**CITY OF ALBUQUERQUE
PLANNING DEPARTMENT
April 22, 2015
DRB Comments**

PROJECT # 1003613

APPLICATION # 15-70159

RE: Sunset Villa Subdivision

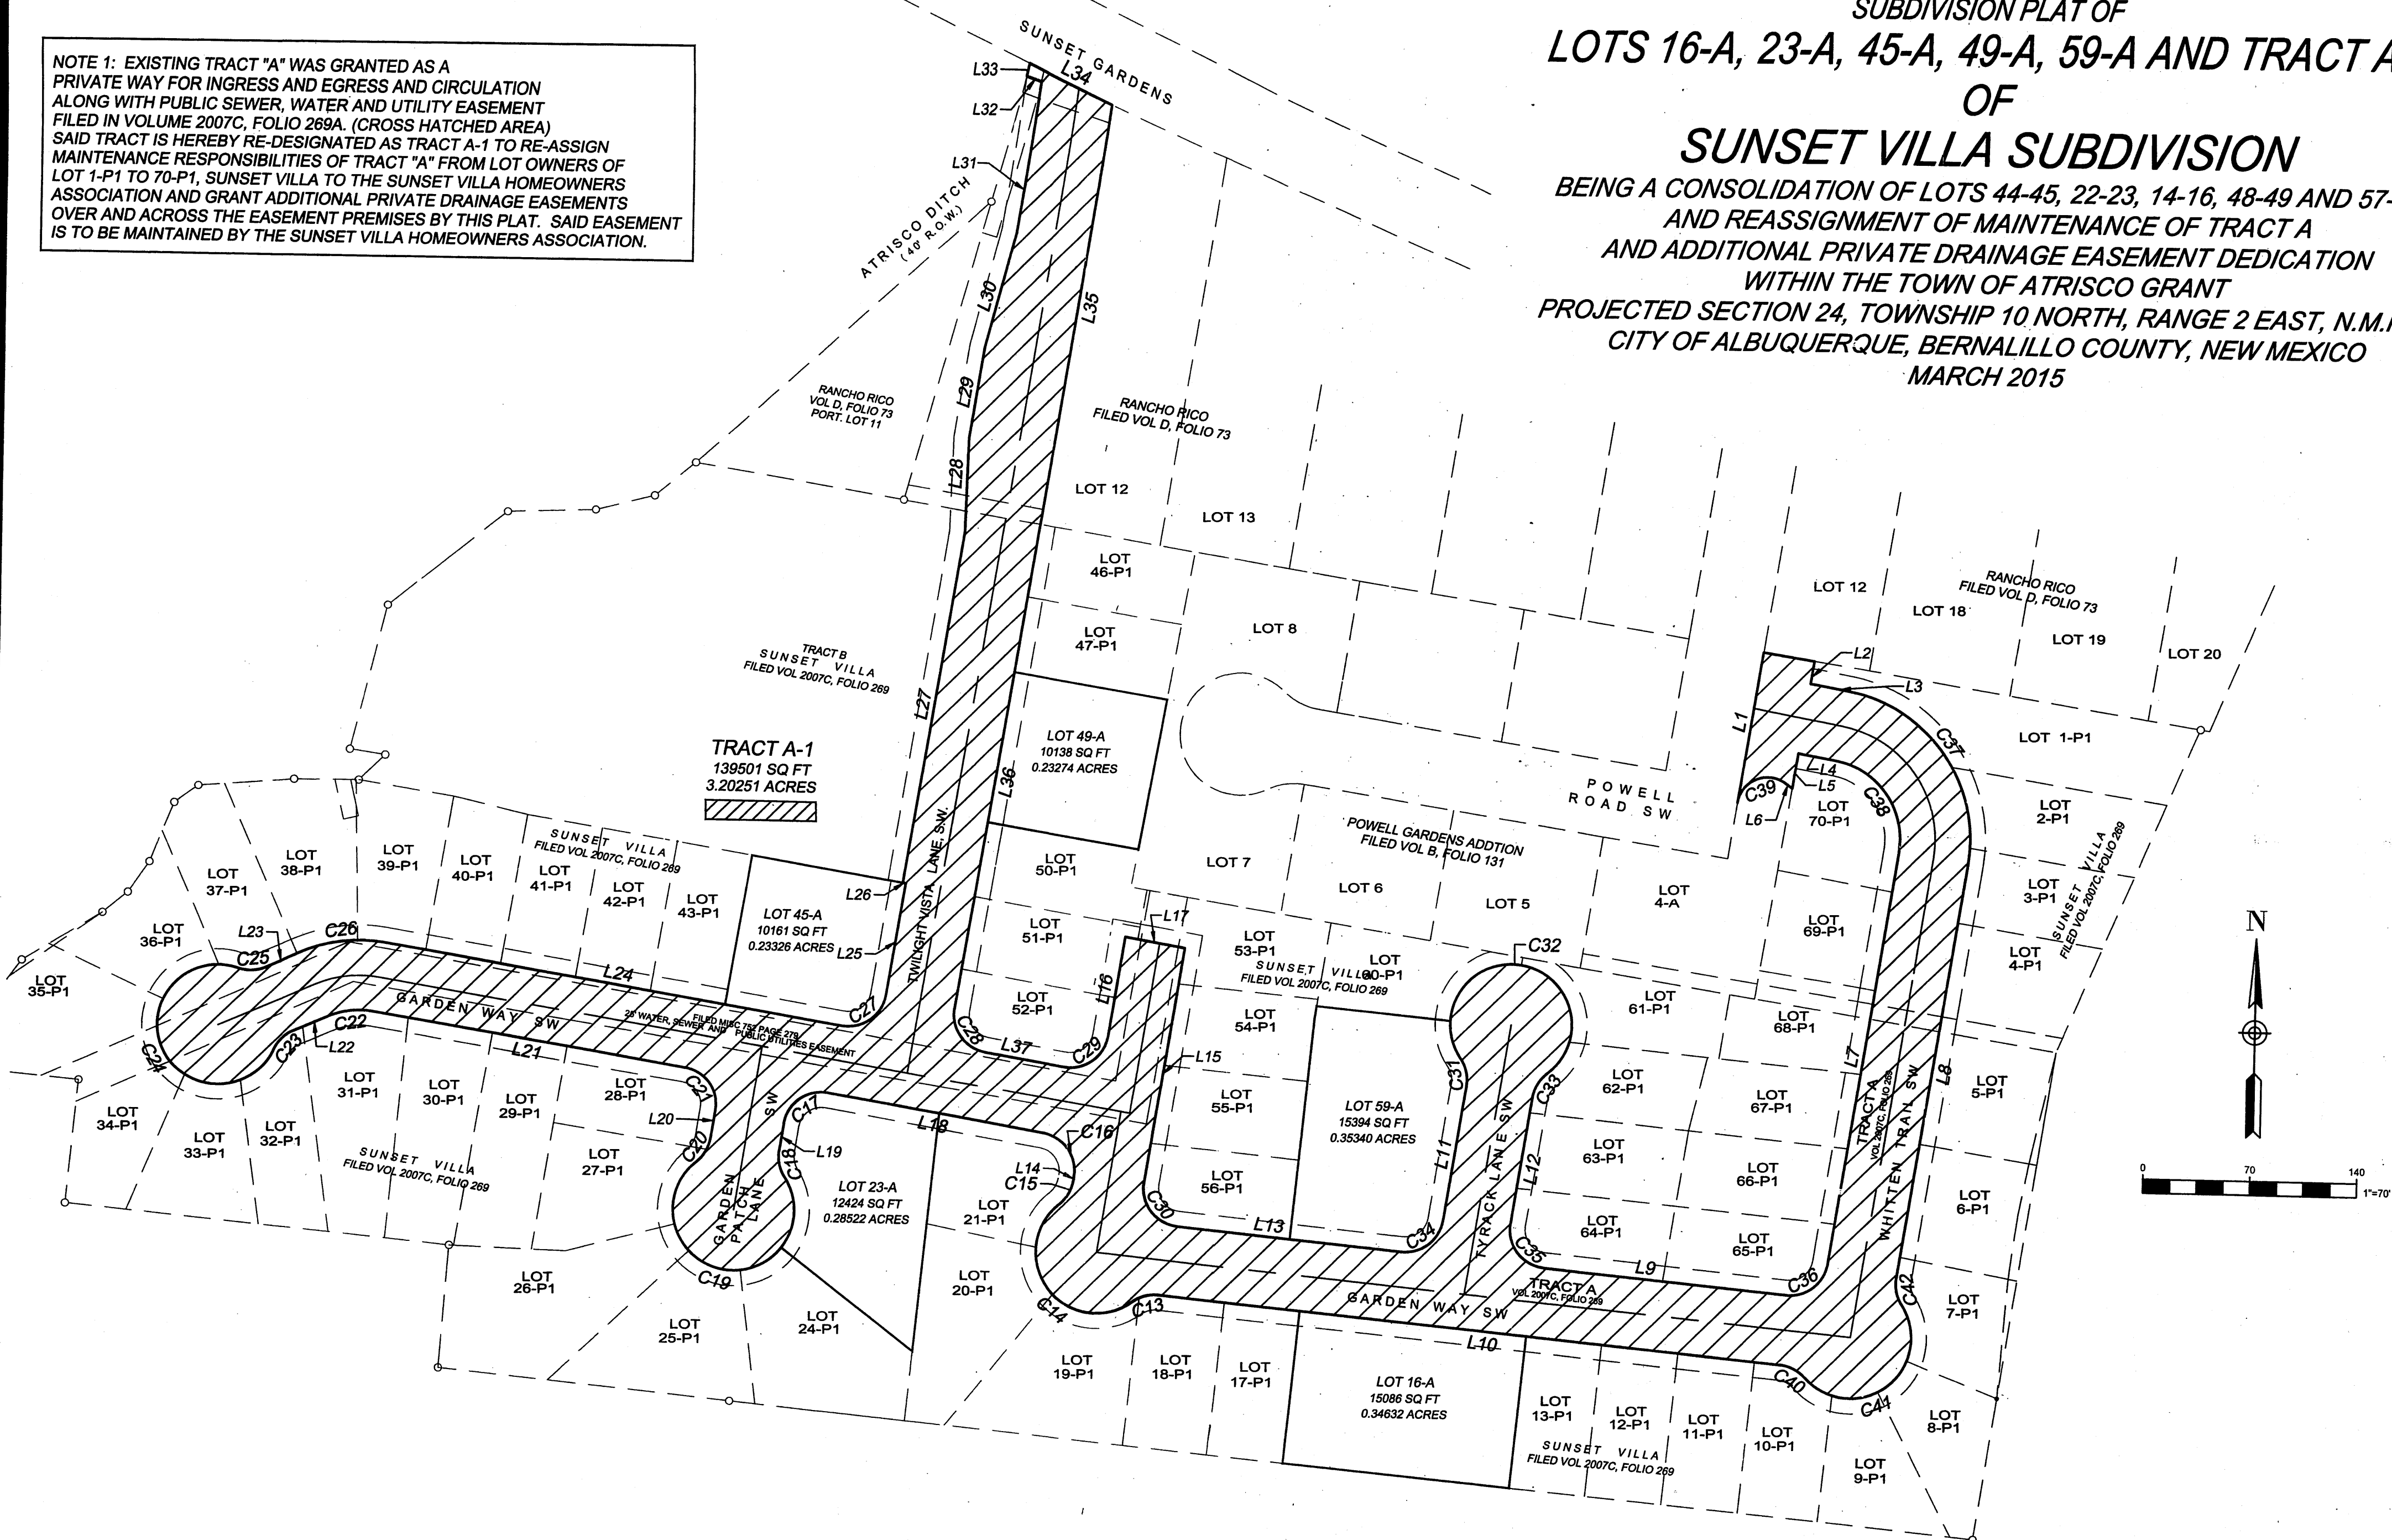
It is unclear why Tract A is being replatted just to add an easement. Additionally, lot consolidations for new ponds should probably be designated as Tracts rather than Lots – refer to comments from Hydrology.
